LU/105/20/L

Listed building consent for external repair works & minor alteration to hidden valley roof arrangement

Roof Floor Plan

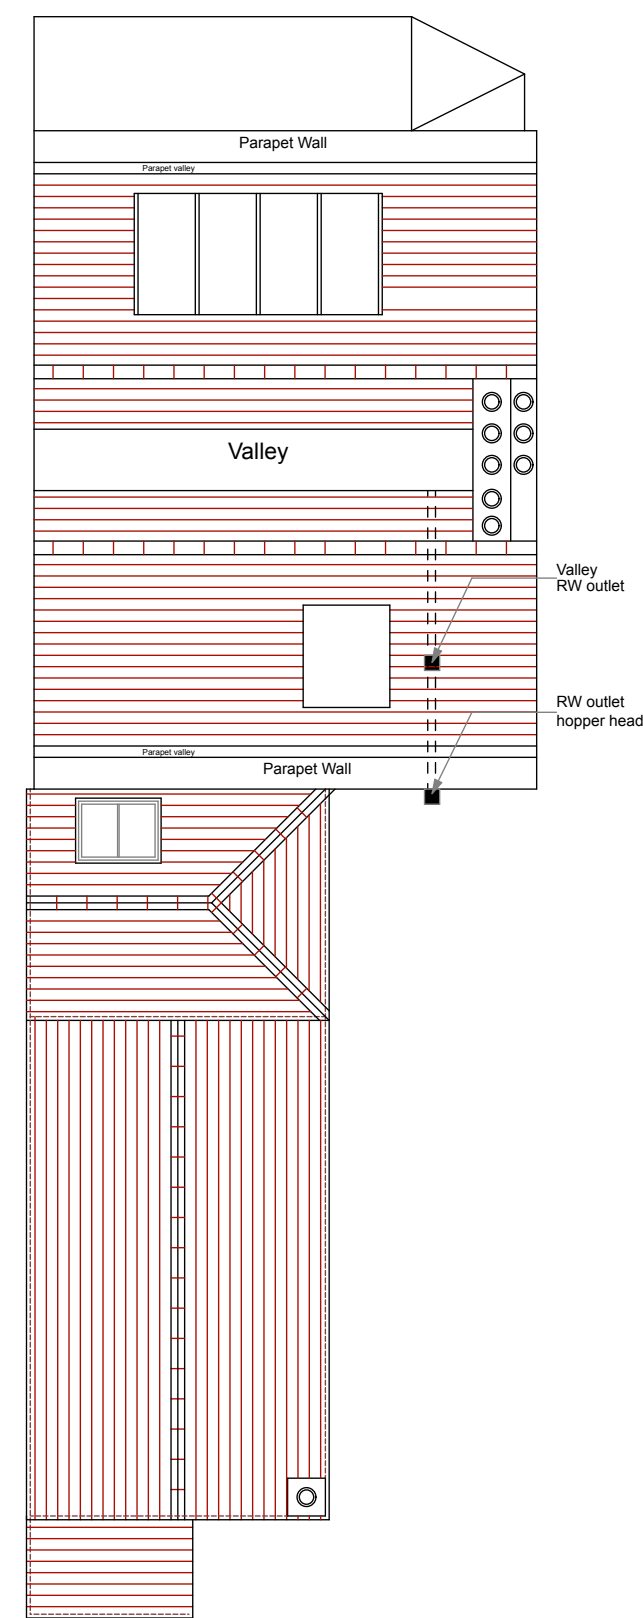
Following poor weather the intention is to undertake works so that a new hidden flat roof with EDPM and install leadwork over ridges. The intention behind this is to ensure that the area to be covered will not be flooded which it is believed was the case of previous problems at the property. Based on the drawings provided, this new section of roof will not be visible from the street (nor should it), and will be covered in a traditional material. It is considered that such an alteration will not harm the significance of the buildings and will hopefully ensure that the previous flooding incident will not be repeated.

203076/02

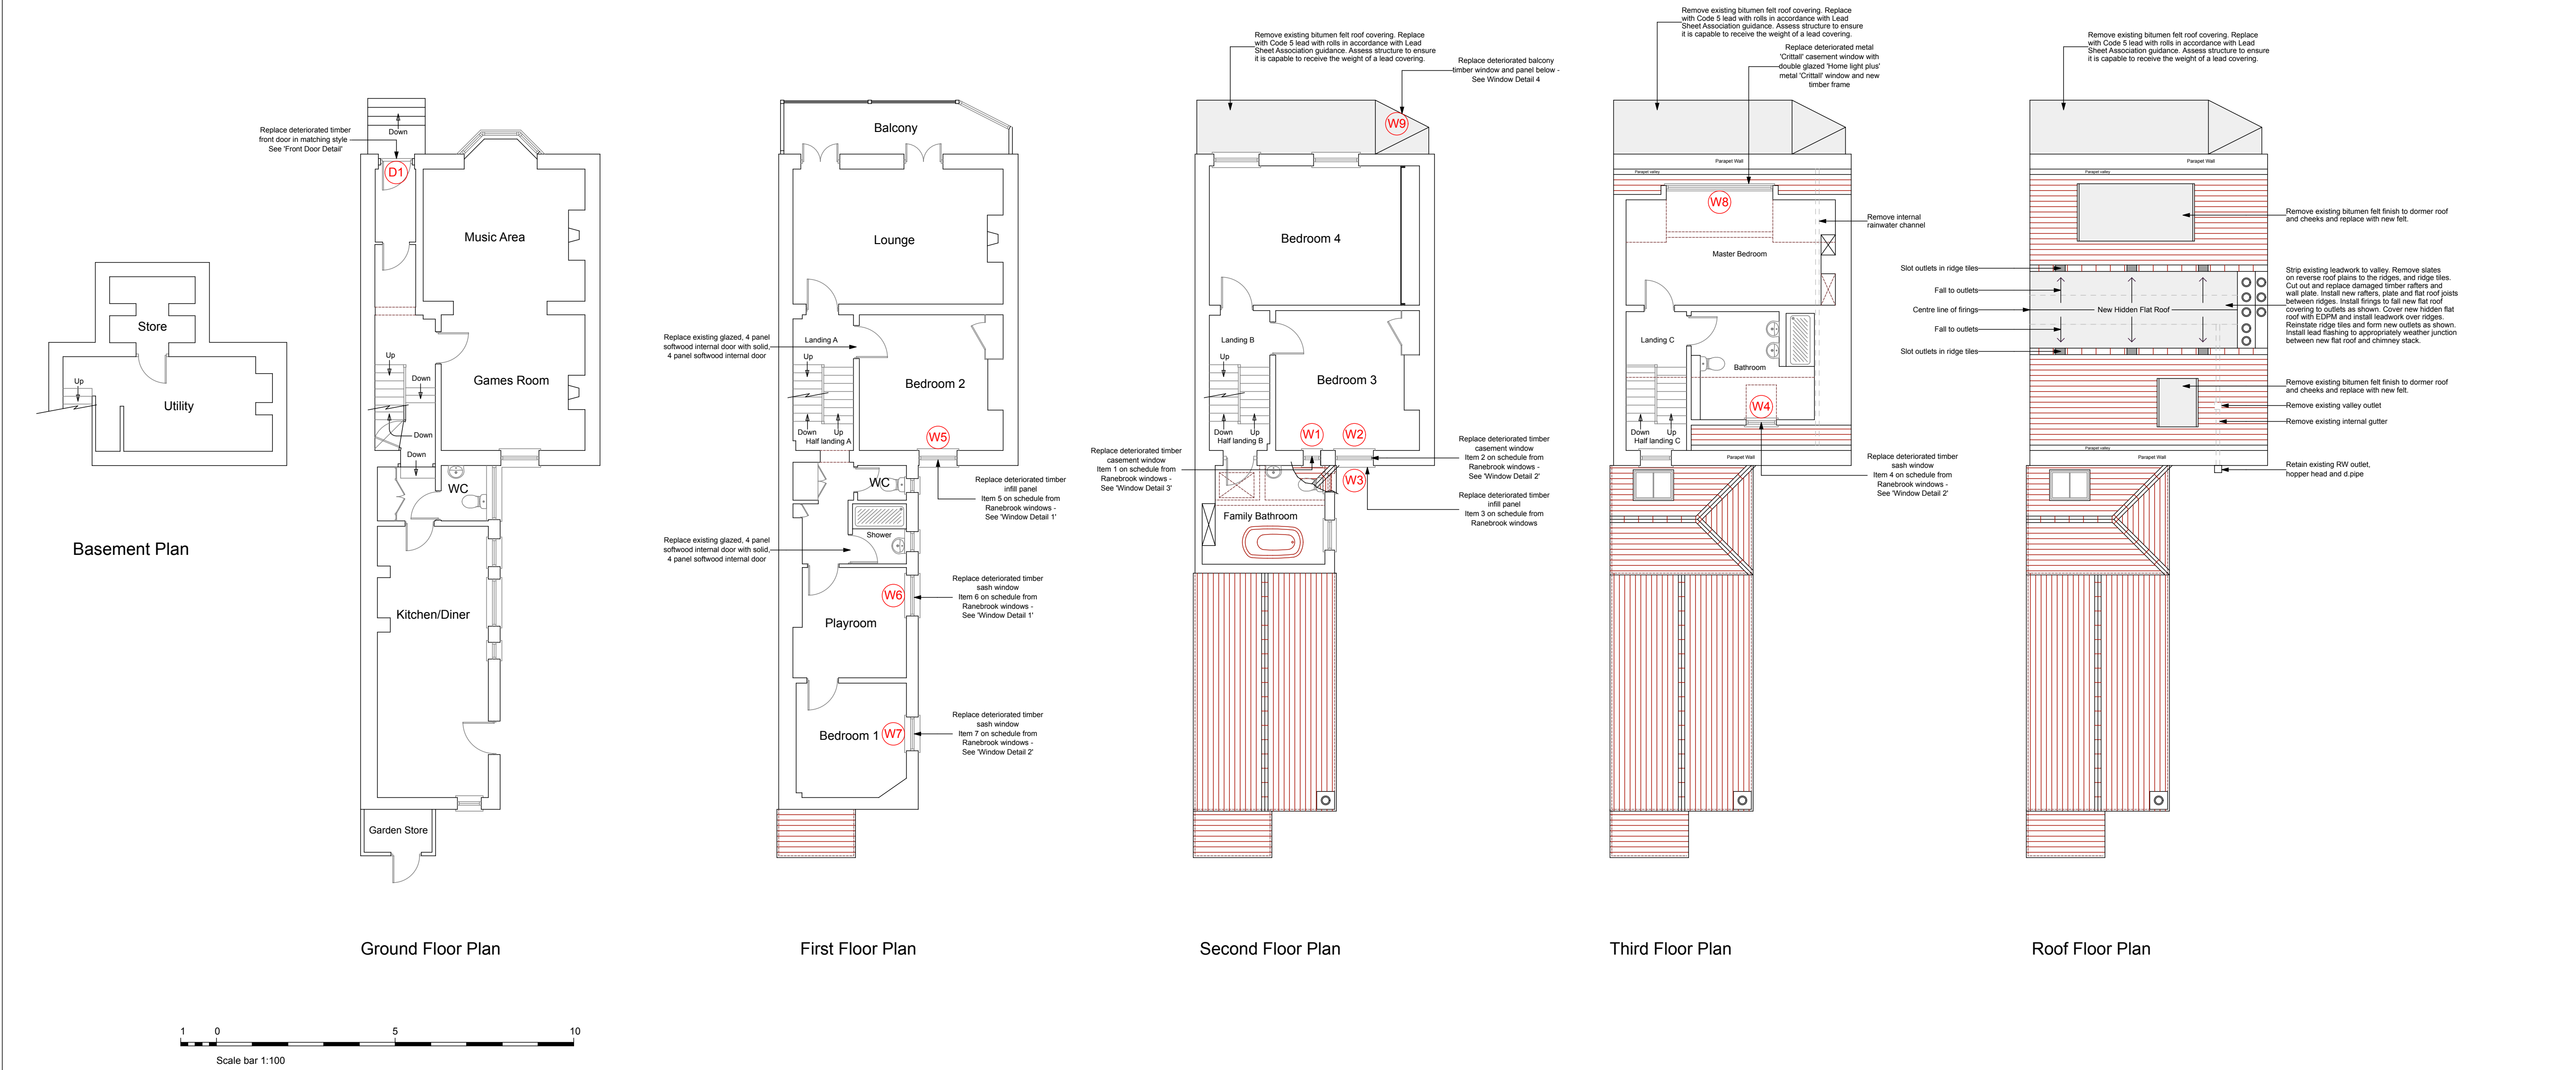
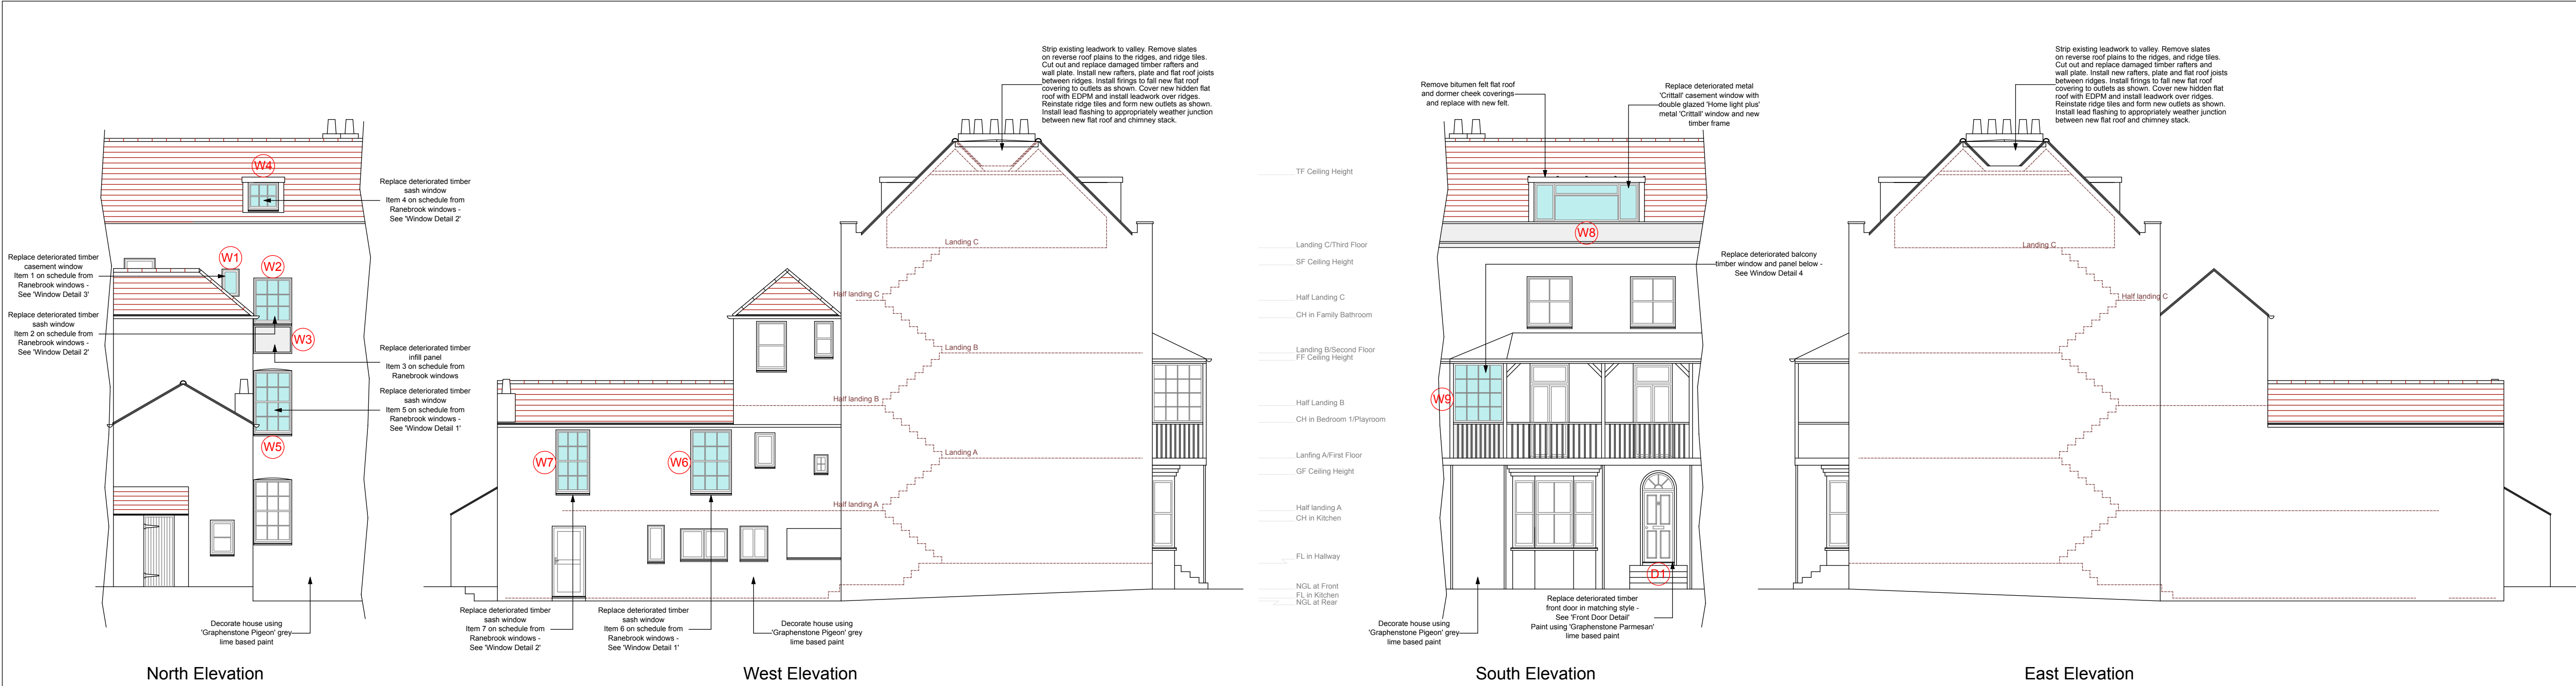
The replacement of deteriorated timber windows and front door with a matching profile and specification is acceptable as it will maintain the existing appearance of the windows. However, it is not clear why the fanlight over the front door has to be double glazed with applied glazing bars. Such a feature is not positive in a listed building. further, all of the glazing bars should be integral to the windows and not applied

The intention to strip the existing bitumen felt balcony hood roof covering and replace with lead is considered to be an enhancement to the appearance of the elevation, and therefore the conservation area.

The loss of the existing window to the front (South) dormer, with a modern equivalent aluminium window is of no concern, and the intention to replace it with something of a similar nature will not harm the heritage assets. It is not clear why a grey colour has been identified, but if it is in an attempt to reduce the impact of the front elevation, its use could be supported in this particular instance.

However, the redecoration of the house in Graphenstone Pigeon Grey and the front door is problematic in terms of the proposed colours. The colours are not traditionally associated with a historic building and it is considered that they would be harmful. It is suggested that the proposed colours be more appropriate for a listed building and a conservation area in order to ensure that the desired positive impact is achieved.
